Martin Nugent  
01254 828060  
D3/11/0784

**Outline Planning Application, Ribble Valley District  
3/11/0784 Old Whalley Nurseries, Clitheroe Road, Whalley**

EXISTING

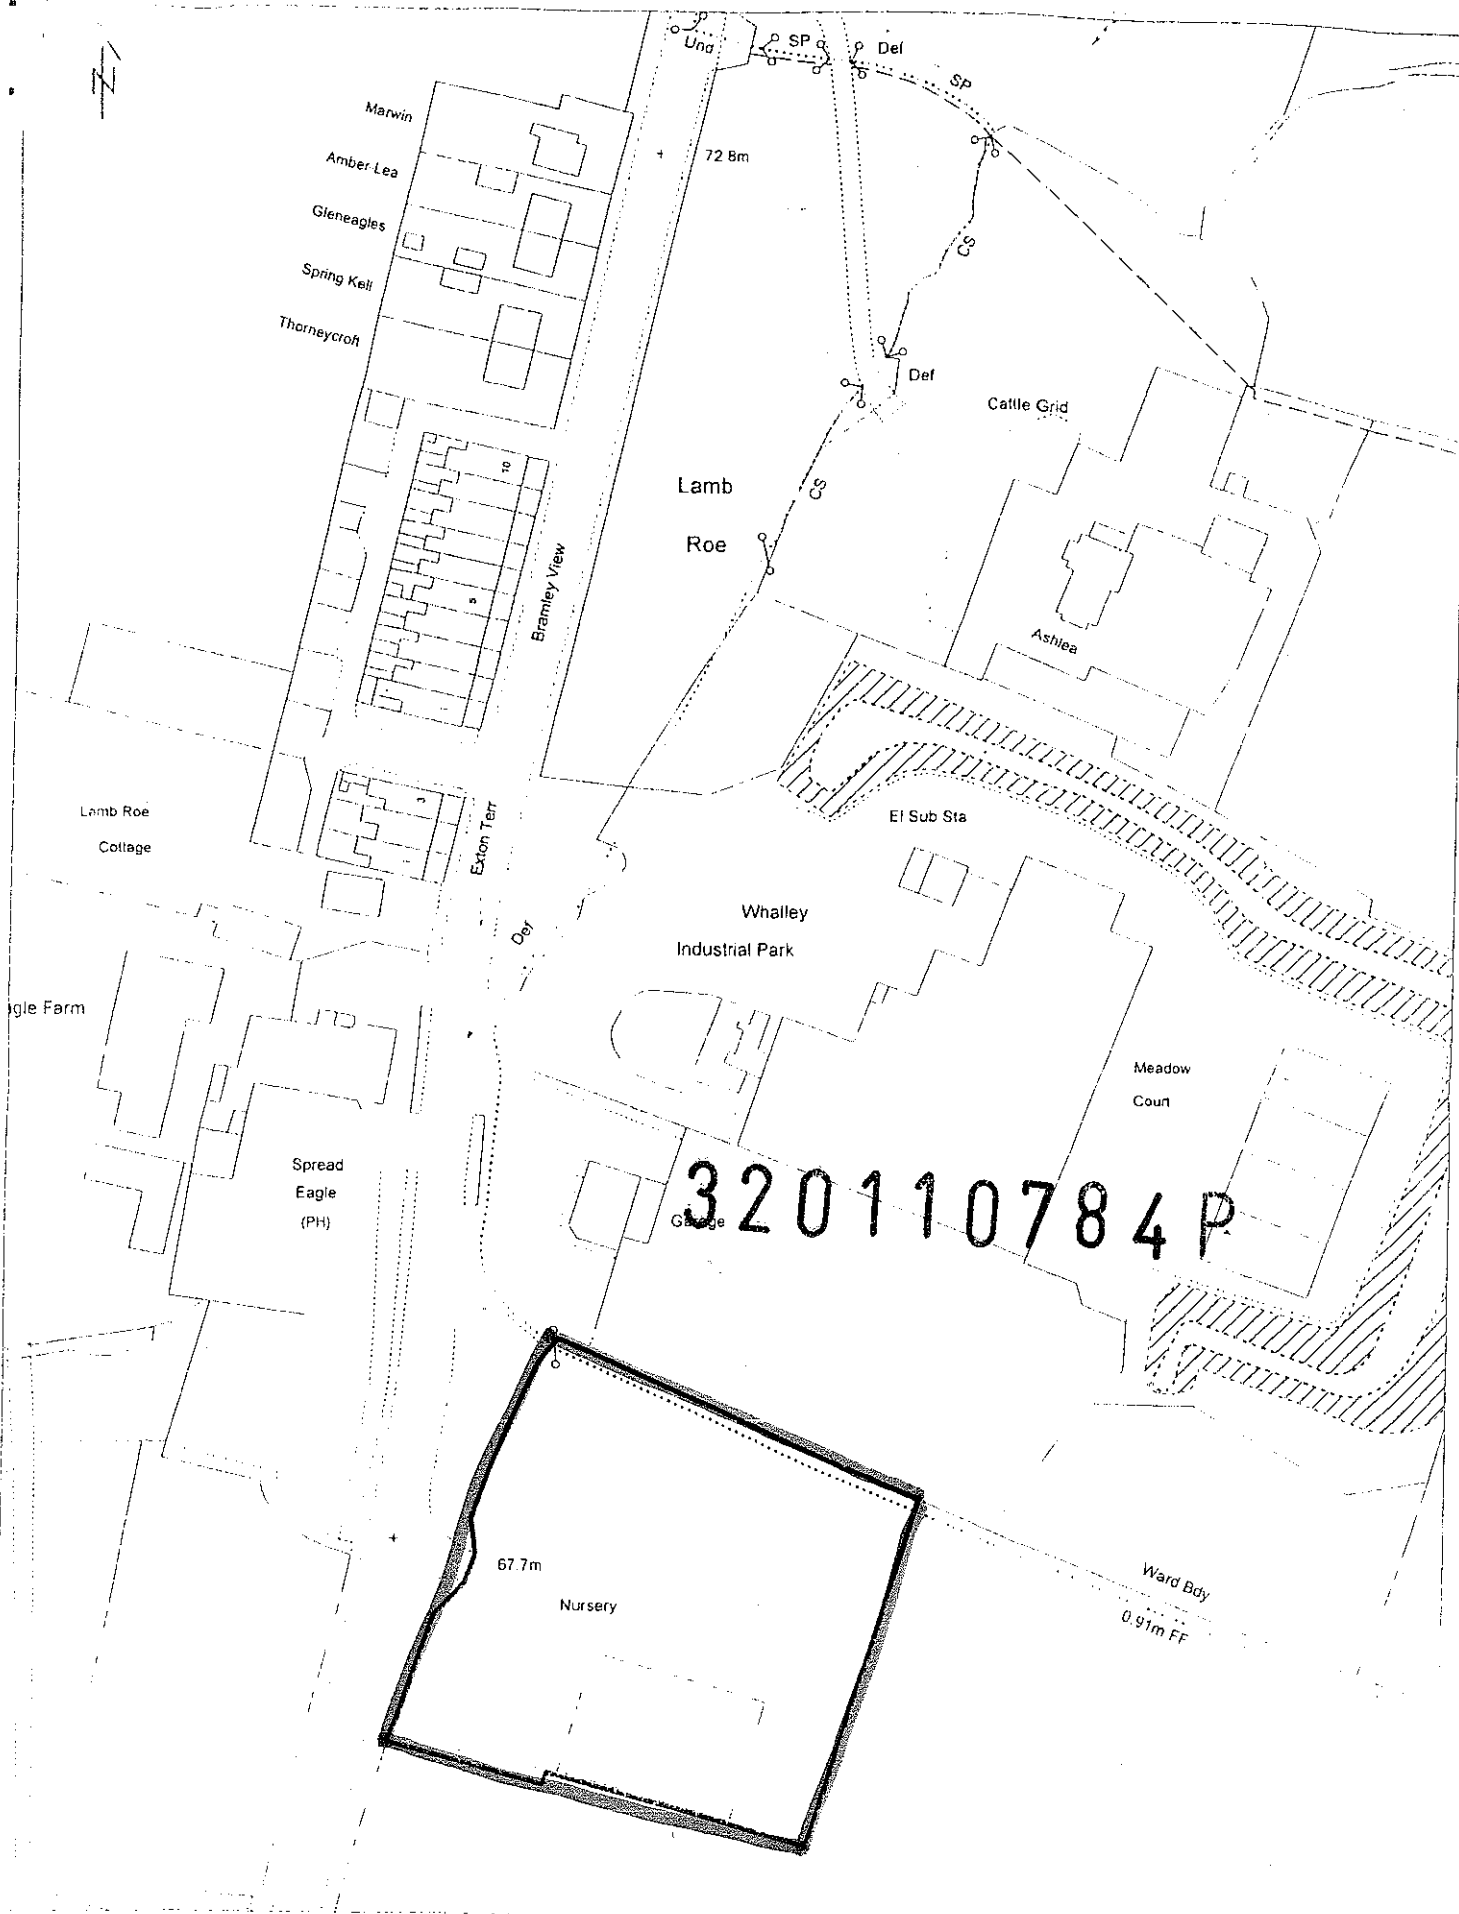
The dimensions of the existing access, as agreed in 1991 for the previous garden centre use, provide an acceptable basis for the access to the proposed site. I will require a more detailed site plan that confirms the sightlines that will be achieved and secured from this access. In view of the highway characteristics at this location, I will require the applicant to show sightlines of 2.4m by 90m in both directions, with all planting and construction in the areas shown within the relevant visibility splays to be controlled at below 900mm.

The addition of footways to either side of the access, minimum width 2.0m, will be required, with drop kerb links to the existing footway opposite. Consideration will also have to be given to any improvements in the existing street lighting provision.
